AB/127/20/L

Bay Tree House 16 Tarrant Street Arundel BN18 9DJ

Satellite dish to internal valley, retention of existing neighbour's TV aerial & removal of redundant tv aerial to east chimney

PROPOSED ROOF PLAN

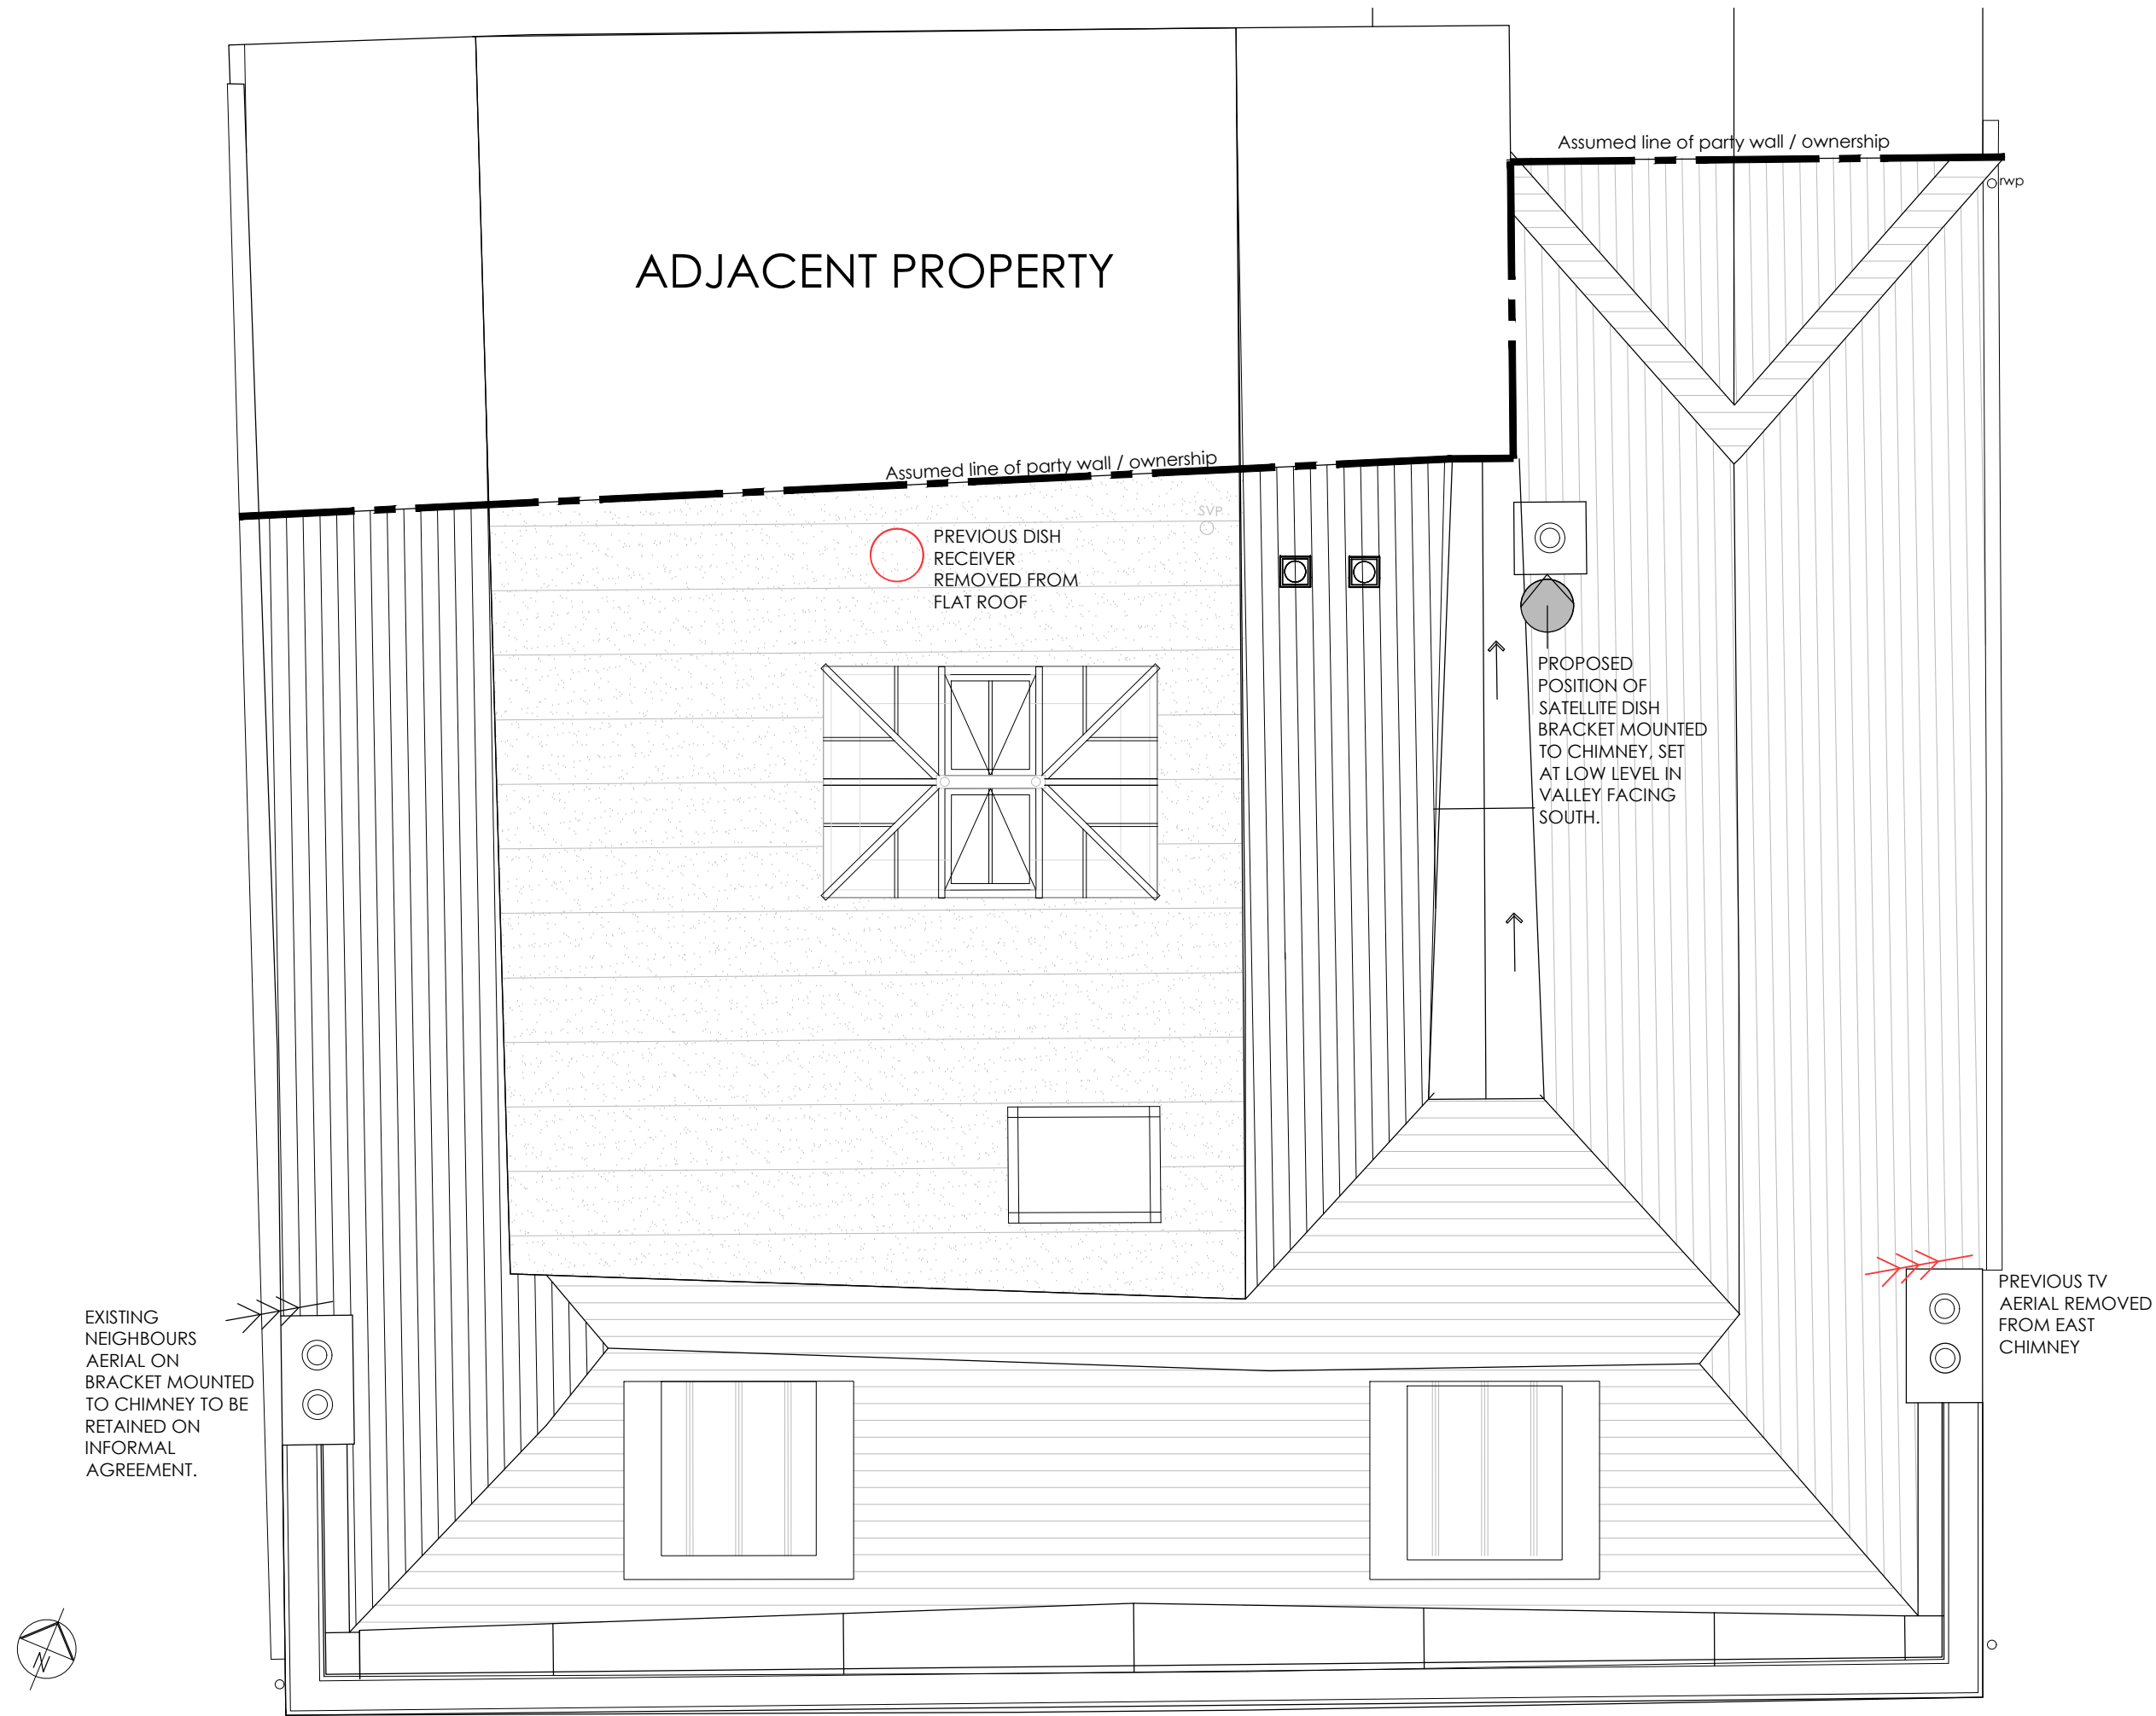
The application relates to the provision of a satellite dish to an internal valley, retention of existing neighbour's TV aerial along with the removal of redundant tv aerial to east chimney. This proposal will not only reduce the clutter of aerials and satellite dishes on the listed building, but also those visible on the street-scene. Such a proposal is considered positive and capable of support.
